Alan Varela, Director

April 30, 2024

**Re: Cottonwood Crossing II Lots 2A & 2B at 10088 and 10080 Coors Blvd SE
Erosion and Sediment Control Plan
Engineer's Stamp Date 4/22/25 (B14E010D)**

EROSION CONTROL PLAN

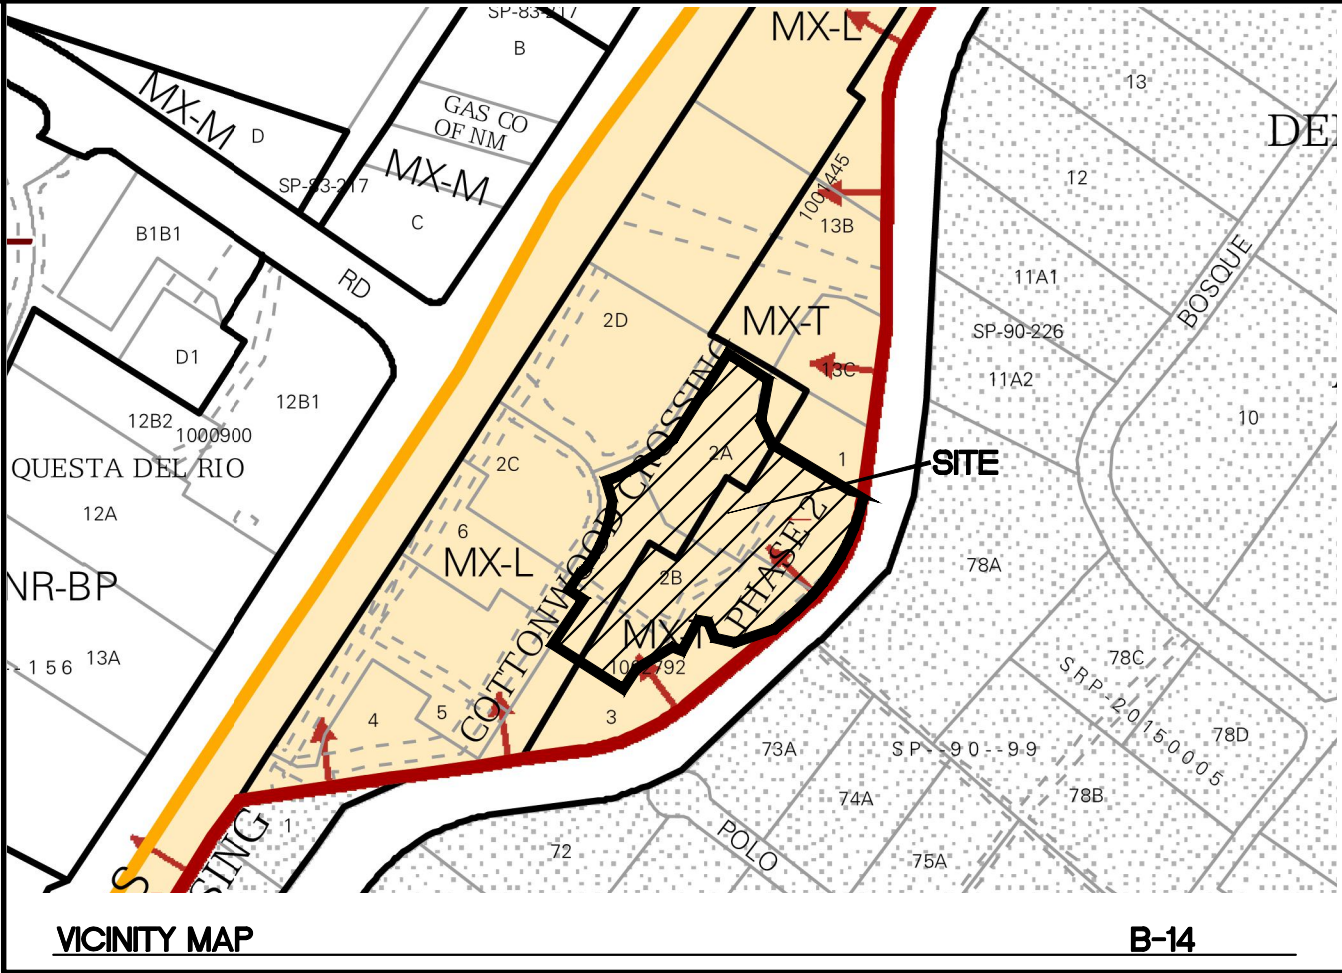
- a. Identify any existing walls to be demolished and new walls to be constructed.
 - b. Add spot elevations at every lot corner around the low perimeter of the site, on both sides of each retaining wall.

- c. Show a temporary berm around the downgradient side of the site per "construction sequence item #3. The berm detail should specify increasing top elevation of the berm as fill is added to the townhouse lots, so it is 18" minimum above the grade of the lots.

2. Clearly identify existing structures and any related demolition activities as required by CGP 7.2.4.b.i. Show the locations of the existing perimeter walls, storm drains, and inlets. Show the existing shotcrete slope paving and limits of disturbance on AMAFCA's property. Identify the timing of each demolition activity in the "Sequence of Construction." Demolition should be shown on a separate sheet to avoid confusion with the proposed improvements.

4. The diversion berm in the southwest corner of the site seems adequate, but the design there may change with the more detailed G&D Plan and Drainage Report submittals to Hydrology and AMAFCA.
5. Add a note on the ESC Plan that says, "New ESC Plans must be submitted to the city for any lots transferred to new owners/operators."
6. The SWPPP must include site-specific interim and permanent stabilization per CGP 9.6.1.c.i. The Landscape Plan can be used to satisfy this requirement and should be submitted separately from the ESC Plan with the application to the Stormwater Quality Section of the Planning Department, and it should be included in the SWPPP. After the Landscape Plan is modified per AMAFCA comments, include a copy with the next submittal.
7. Update the Engineer's stamp date on all sheets when changes are made to any of the ESC Plan sheets.
